NARWEE PARKLANDS CARE COMMUNITY

SSDA SUMMARY OF DESIGN CHANGES FOR DPE

Response to Submission Design Report for the Narwee Parklands Care Community

State Significant Development Application (SSD-45024776)

1 HEIGHT PLANE DIAGRAM - SEPP 9.5m

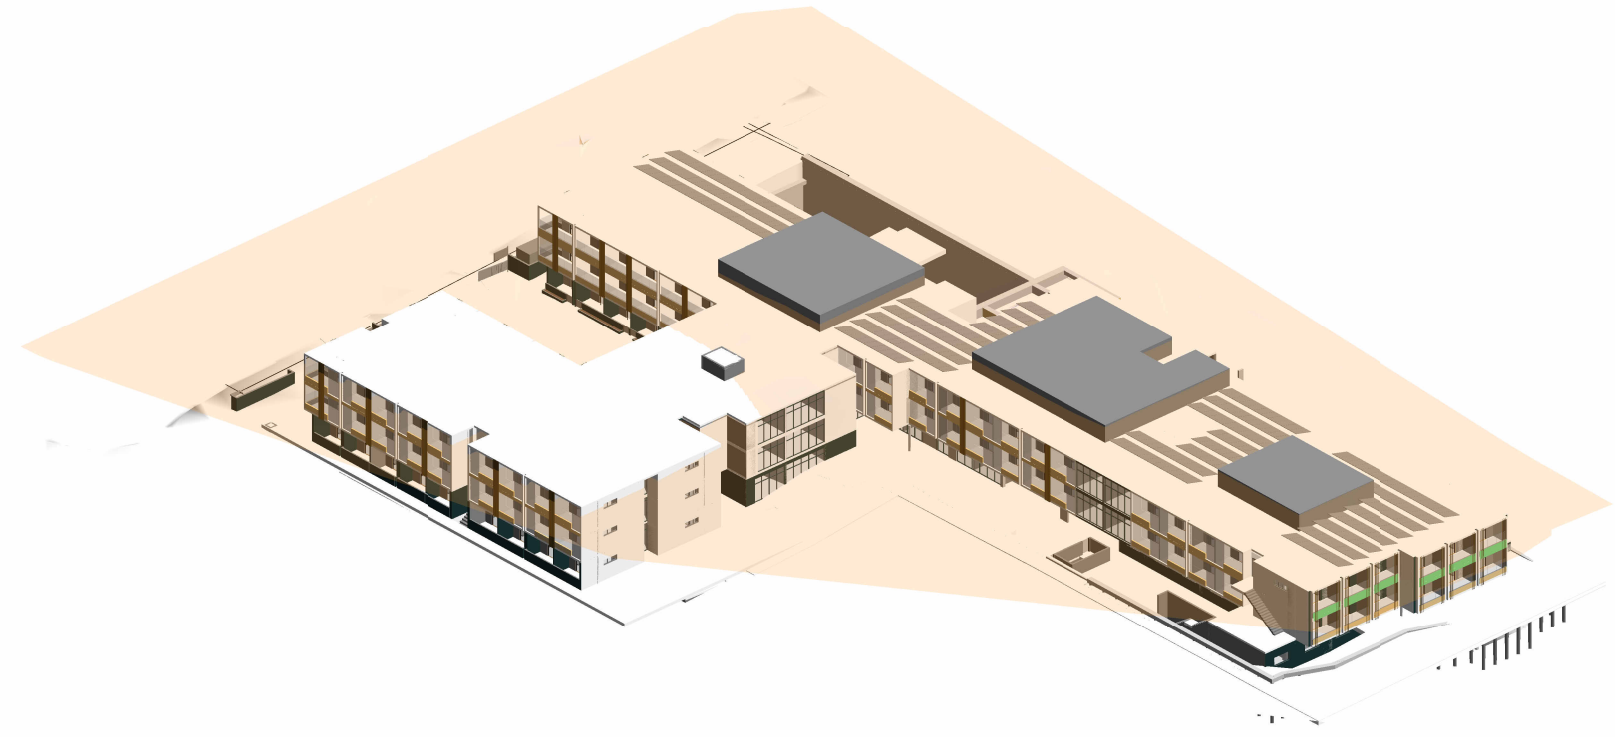
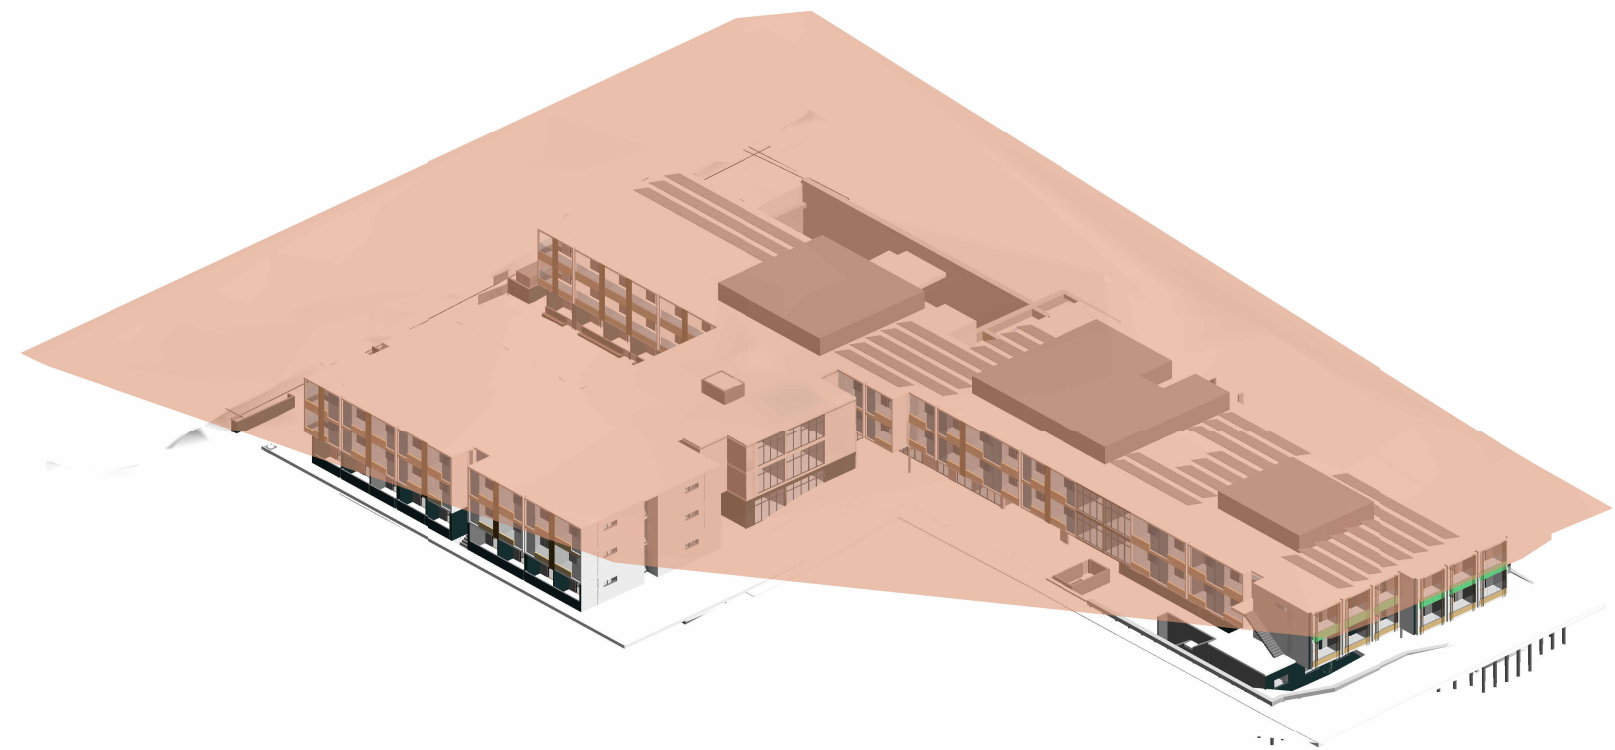
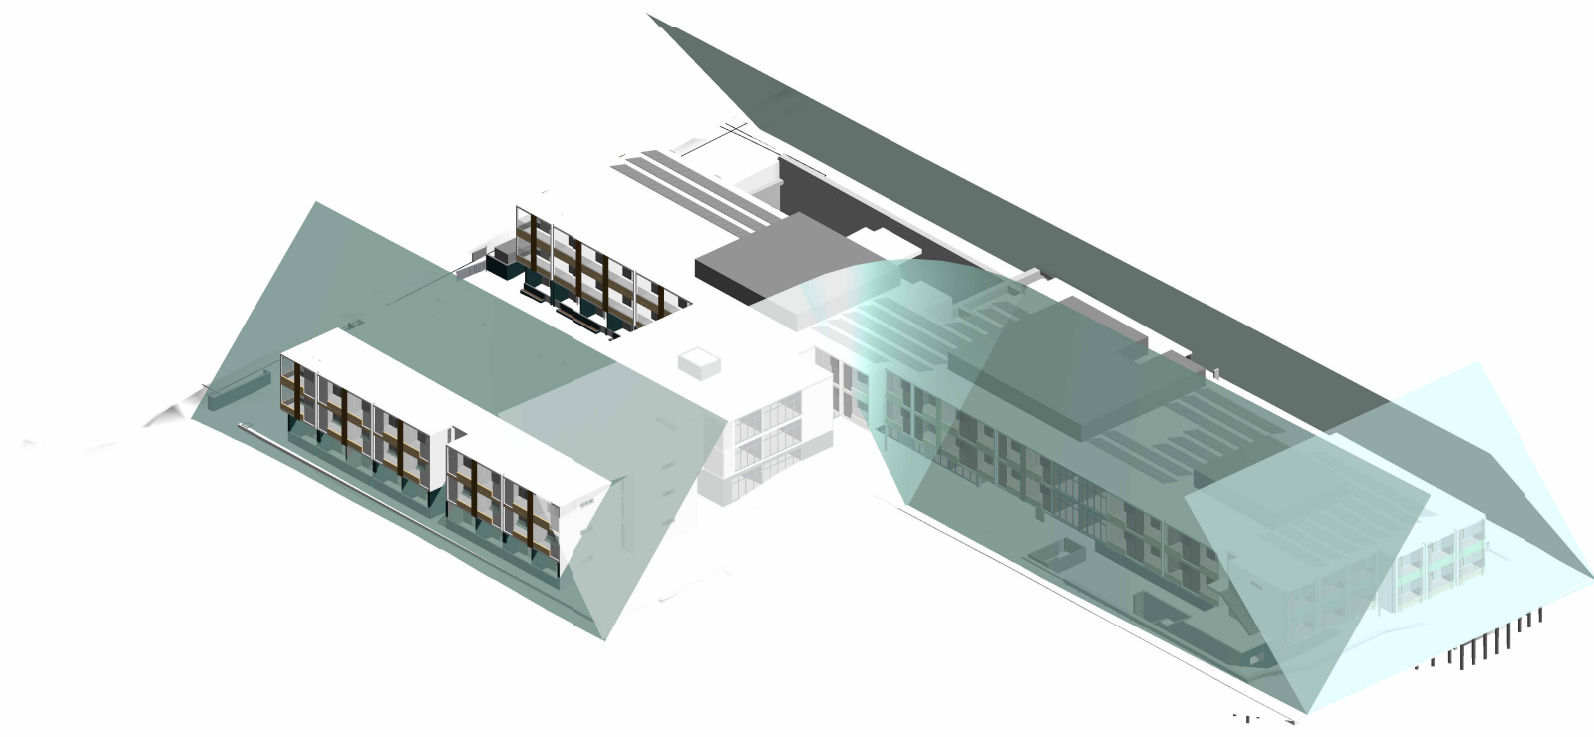
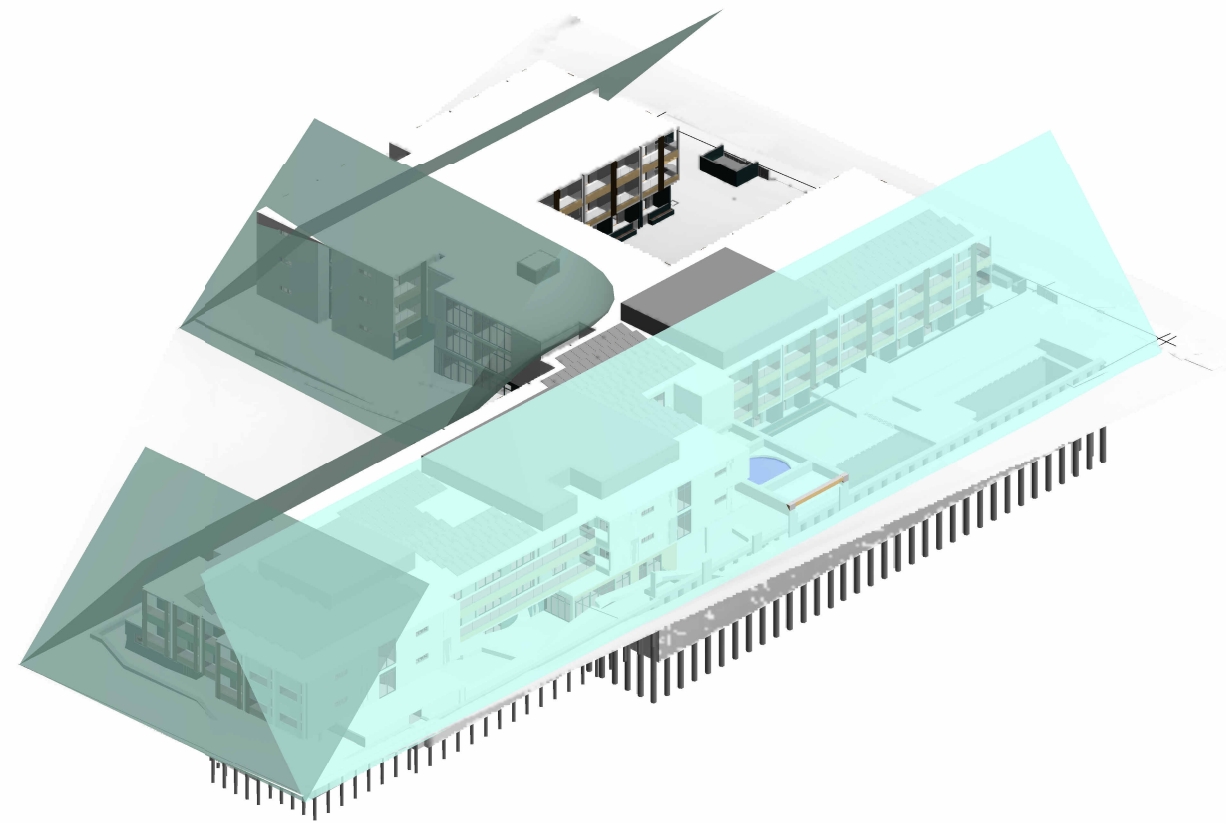
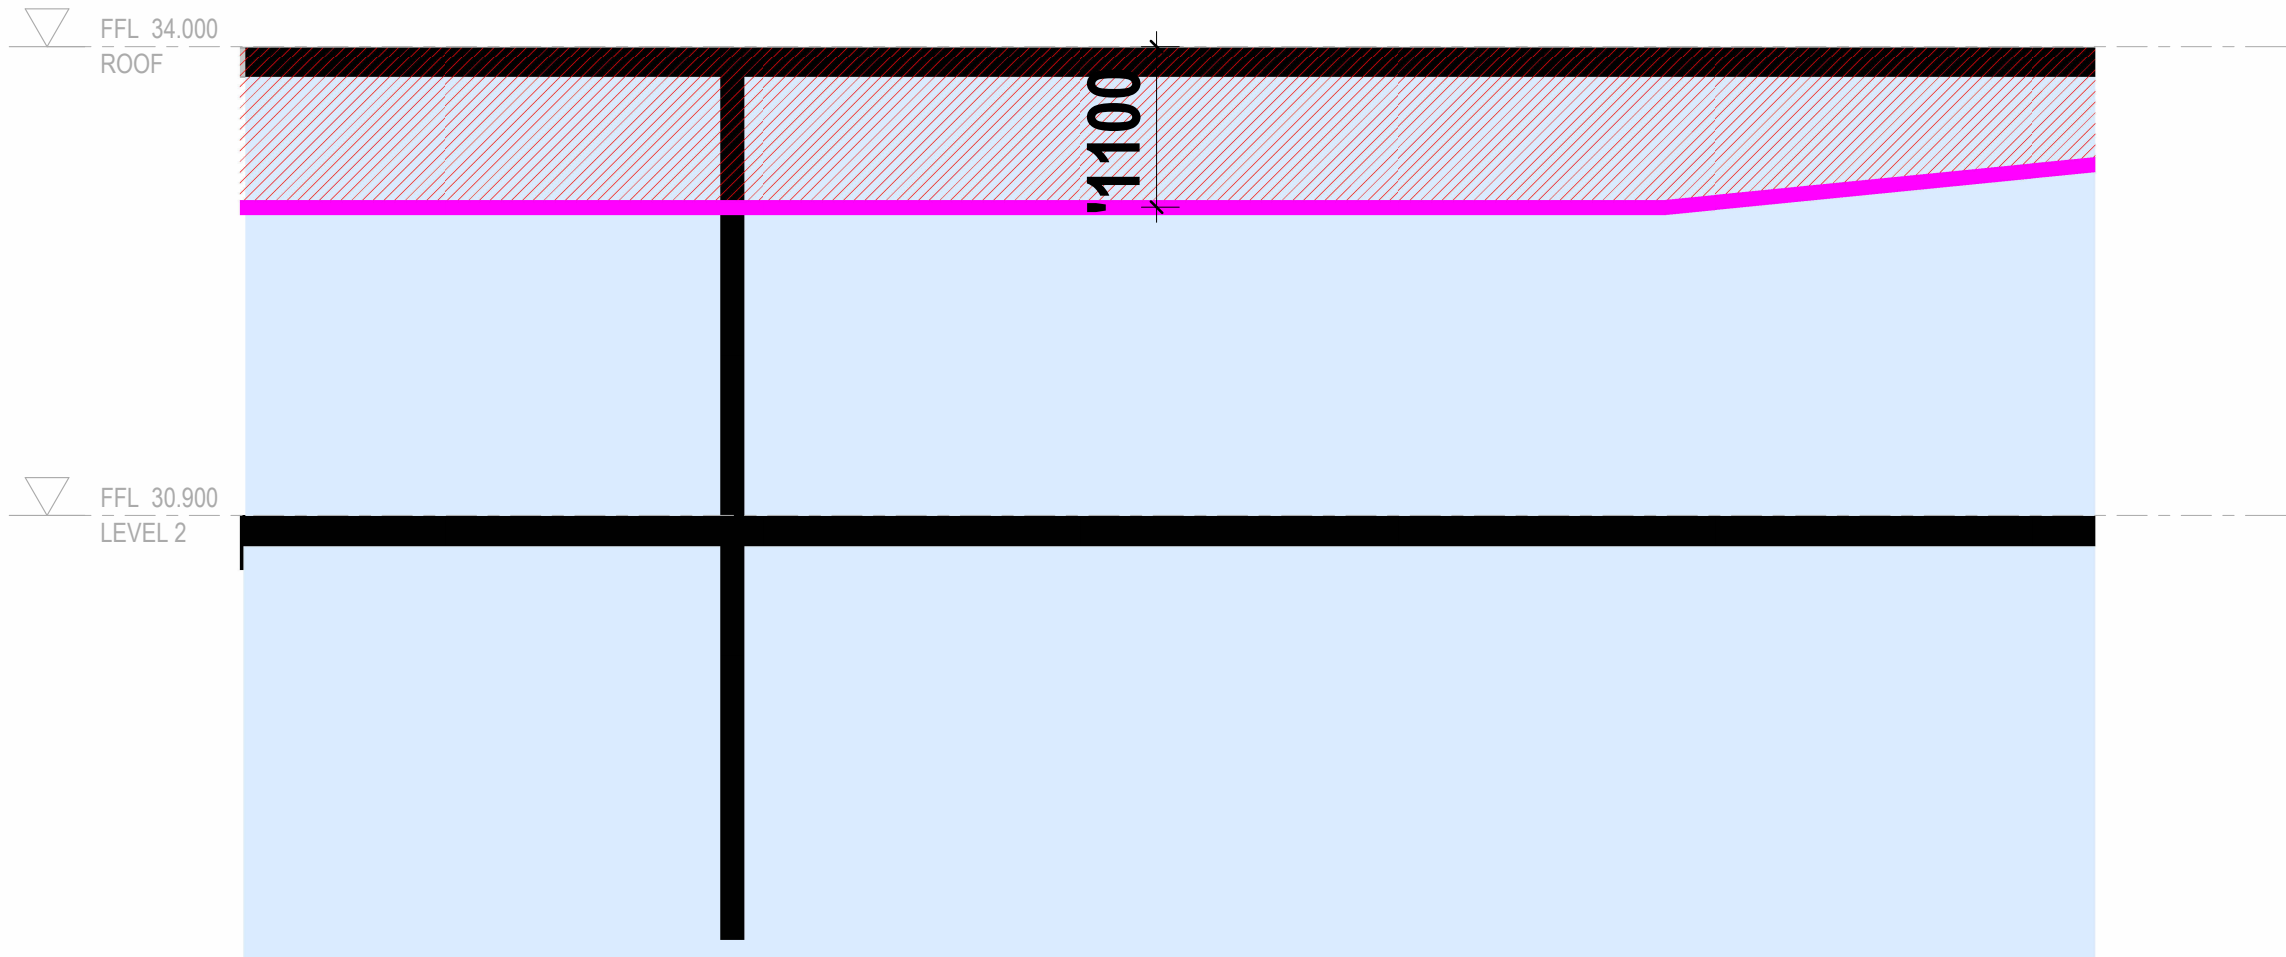
(a) The proposal seeks a variation of 11.6% to the maximum building height development standard and makes no attempt to comply with the 45 degree plane development standard at the southern end of the development as prescribed by the State Environmental Planning Policy (Housing) 2021 (Housing SEPP). The breach of these development standards results in unacceptable outcomes as discussed further below.

(c) Based on the above, the application is to be amended to strictly comply with the development standards, on the basis that the amendments achieve a suitable outcome for the site. Particularly, it is noted that a reduction in the number of units and/or a revised floor plan may be required to achieve suitable amenity outcomes. However, should an amended application continue to exceed the development standards, complying floor plans and elevations are to be submitted to demonstrate why the proposed development achieves a better outcome and provides better amenity for the site and surrounds.

Shadow diagrams reference to the previous development removed with amended shadow diagrams identifying the impacts with the proposal against the developable housing SEPP housing compliant envelop diagram.
